From: Harry Chalk
Sent: 07 April 2022 09:50
To: Planning Scanning
Subject: FW: R/25/22/HH

PROPOSED WEST ELEVATION PROPOSED SOUTH ELEVATION PROPOSED EAST ELEVATION PROPOSED NORTH ELEVATION

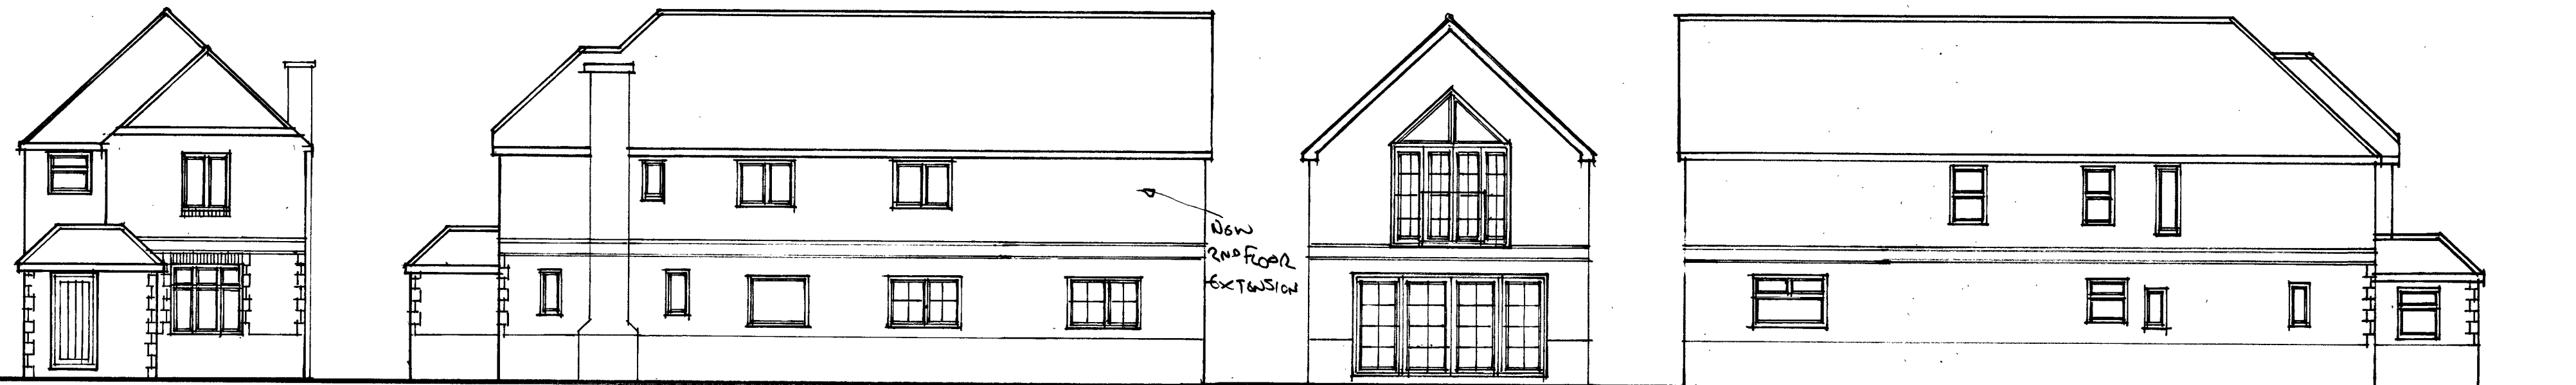
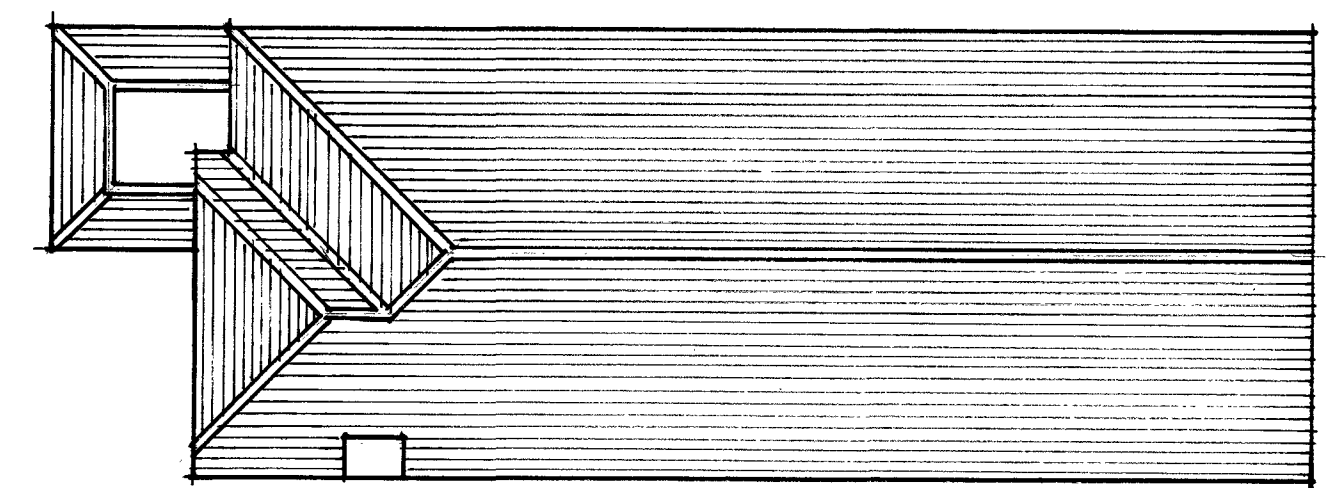
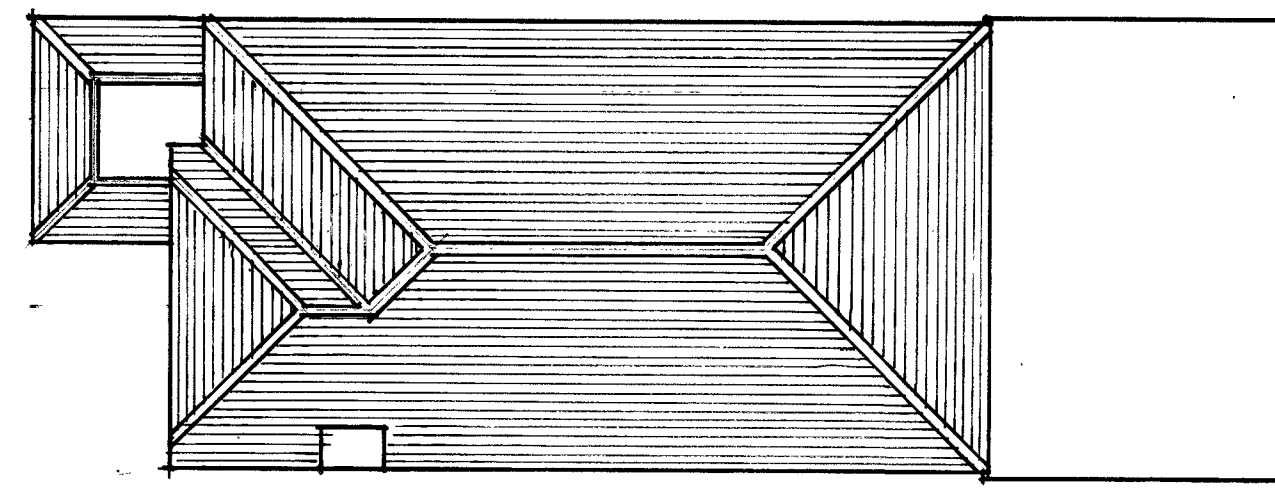
Just a quick one before I go away on annual leave at midday today, I am under the impression the car port roof will consist of grey tiling similar to that of the car port a few houses down. The plans and application form do not give explicit indication as to the materials for the roof further than that of tiling. Could I just get you to confirm the proposed tiling for the car port roof?

I can confirm that the roof of the Car Port will match the tiles on the existing house which are a concrete plan tile in antique red.
